From: Martyn White
Sent: 31 August 2018 11:47
To: Simon Davis
Subject: Y/20/18/OUT

Y/20/18/OUT

The proposal is for the erection of 10no dwellings in the hamlet of Flansham. I note that the current application is a re-submission of a previously withdrawn one. I provide comments on the basis of the current application only, but realise that comments have previously been provided by another conservation officer which have influenced this proposal before me.

Figure A2: Proposed Site Master-Plan Illustration

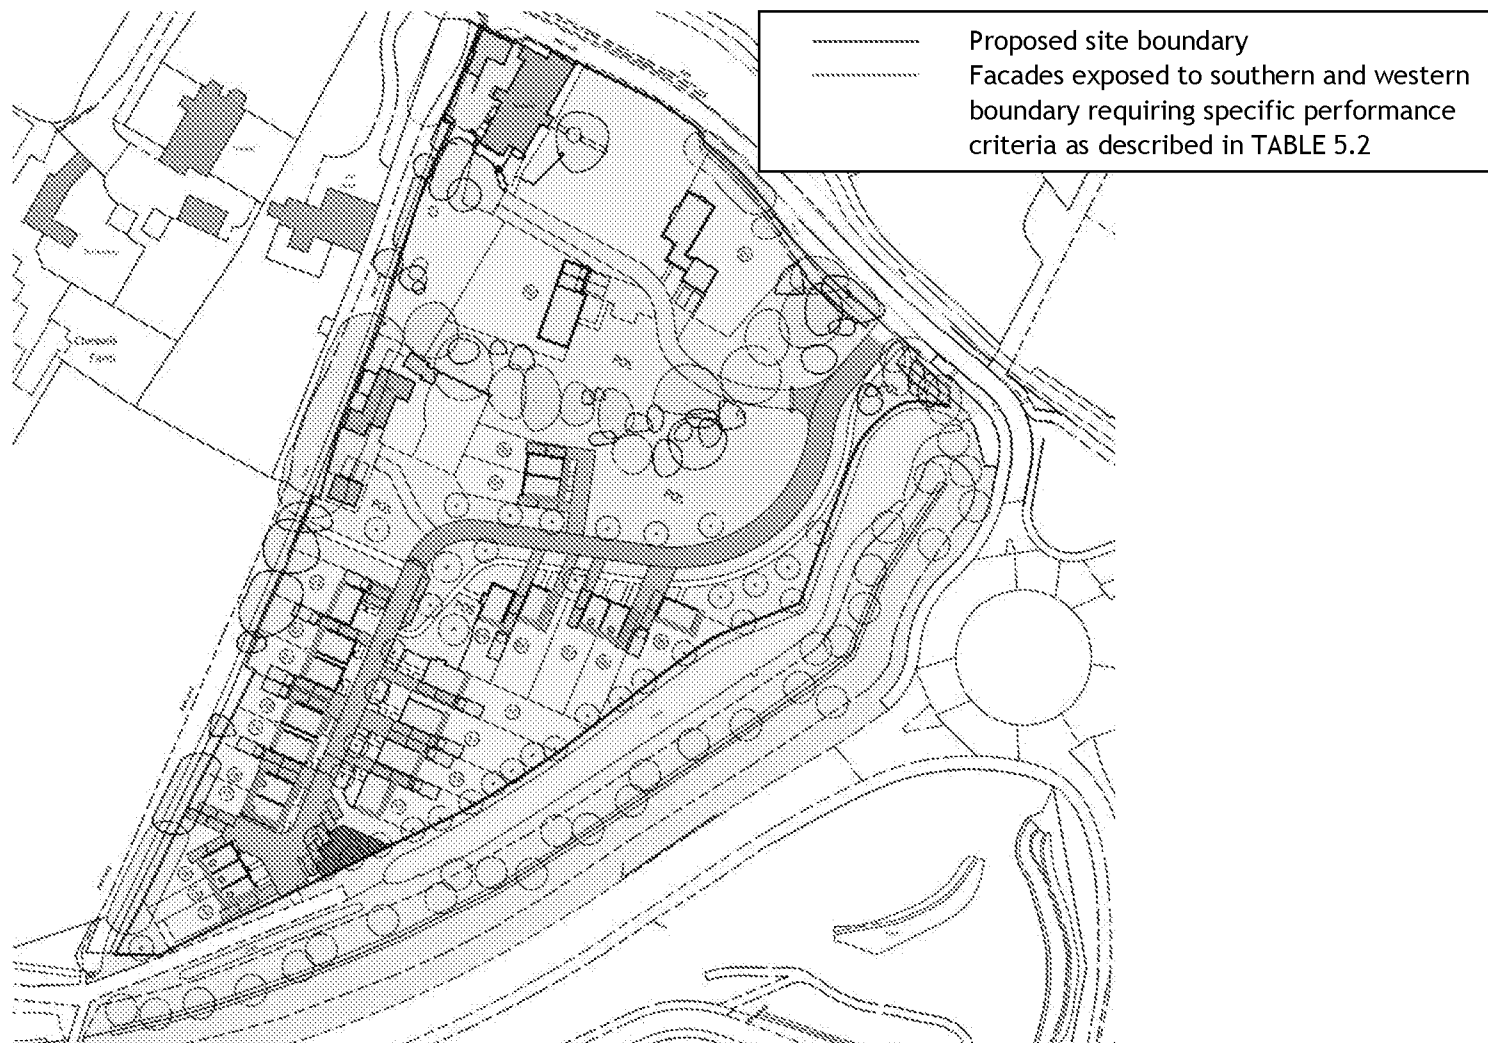
These new properties should be of high quality design, and respond to the setting so they make a positive contribution to the hamlet. The proposed plans provided as part of the application indicate that standard house types will be constructed (two from inspection). It is not clear how the new properties respond to or relate to the closest properties to the site; they appear to read as a standalone, inward looking development that is in contrast to the hamlet. One example of a more successful development can be seen around Chessels (House). Therefore, based on the level of information provided so far, it is not clear how the local character of the area is presented in the proposal.

It is considered that in order for a successful development which truly reflects the individual character of the buildings and the area, all of the properties should be individually designed, based on the characteristics identified from within the hamlet.

In addition to the homes themselves, the removal of any mature trees, necessary hard landscaping, parking provision, lighting and other measures would intrude on this 'edgeland' setting.
